Environmental Health Consultation Response

To	Hebe Smith
Date	07-12-2025
Planning Ref	BR/203/25/PL
Site Description	Trevali Belmont Street Bognor Regis West Sussex PO21 1LE
Date of Application	2025-11-21 00:00:00
Category	Application
Recommendation	No Objection No Objection – with conditions Objection Holding Objection

BR/203/25/PL
PL- consultation- EH response

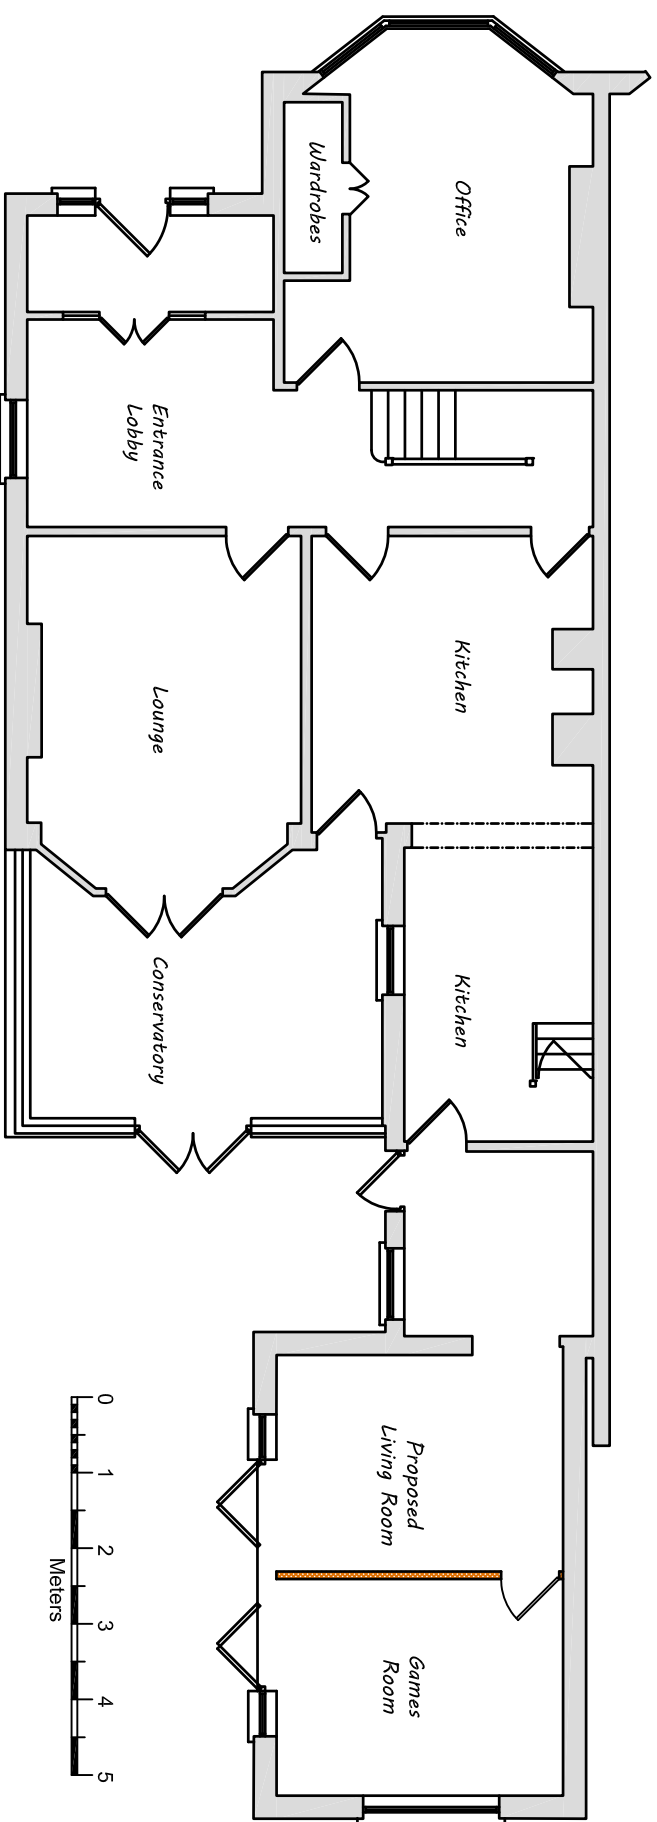
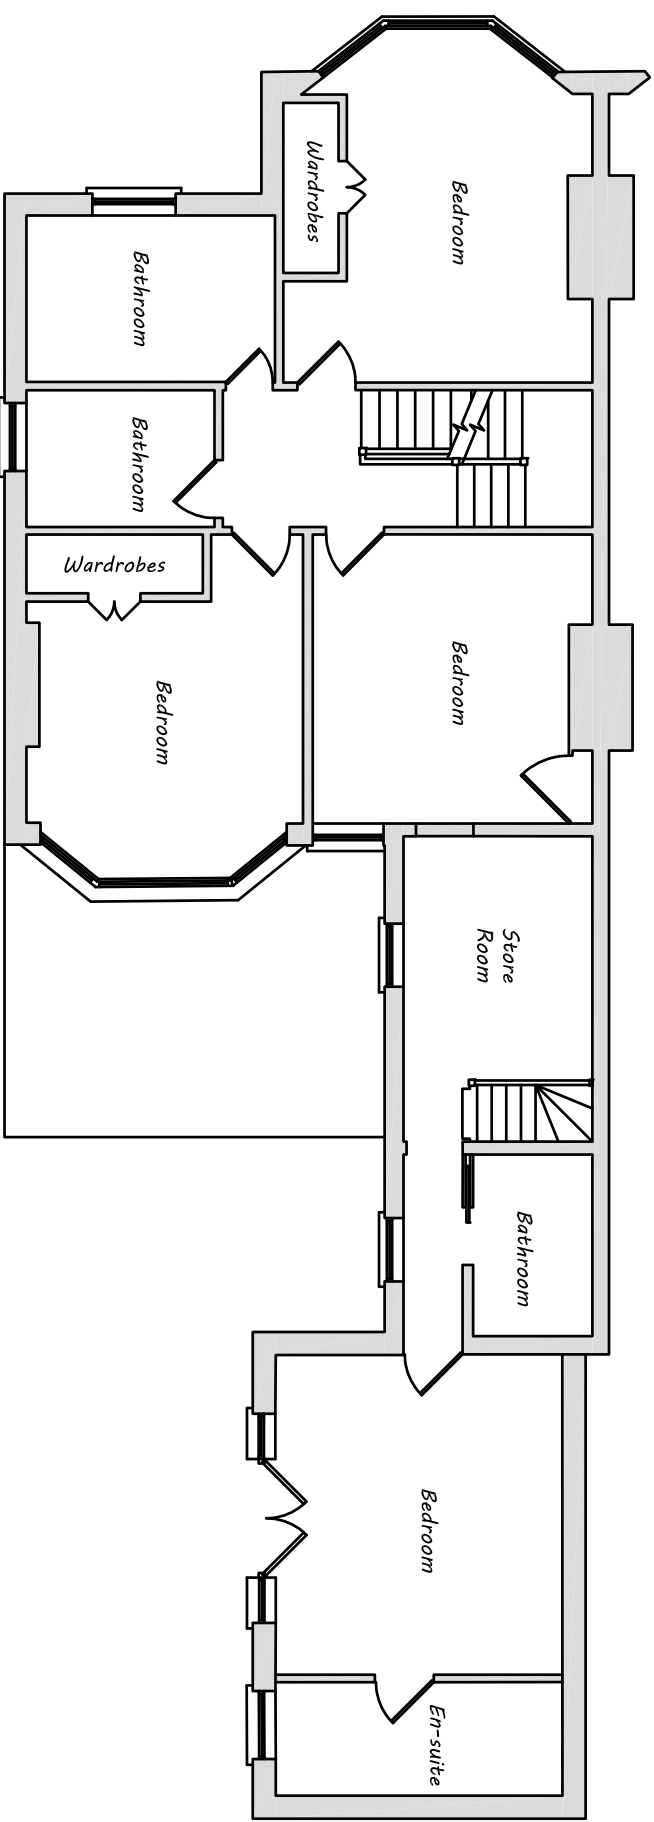
I have received the submitted application, and I am concerned about the impact this proposed change of use may have. Residential care homes for children can result in children with extra sensory needs being placed in a semi-detached property that is not designed for this purpose, such as this proposed property.

I am concerned that the insulation in the house is not satisfactory to protect the neighbours from the noise this use will produce, therefore I would recommend the following condition should consent be granted.

PCEHN13 : Sound insulation - conflicting room uses

The change of use hereby permitted shall not begin until full details of an enhanced sound insulation scheme shall be submitted to and approved in writing by the Local Planning Authority. The scheme shall achieve a minimum of 5dB better than the maximum Building Regulations value for the floor/ceiling/walls separating different types of rooms in adjoining dwellings (e.g. kitchen above a bedroom). The scheme shall be retained and maintained in perpetuity.
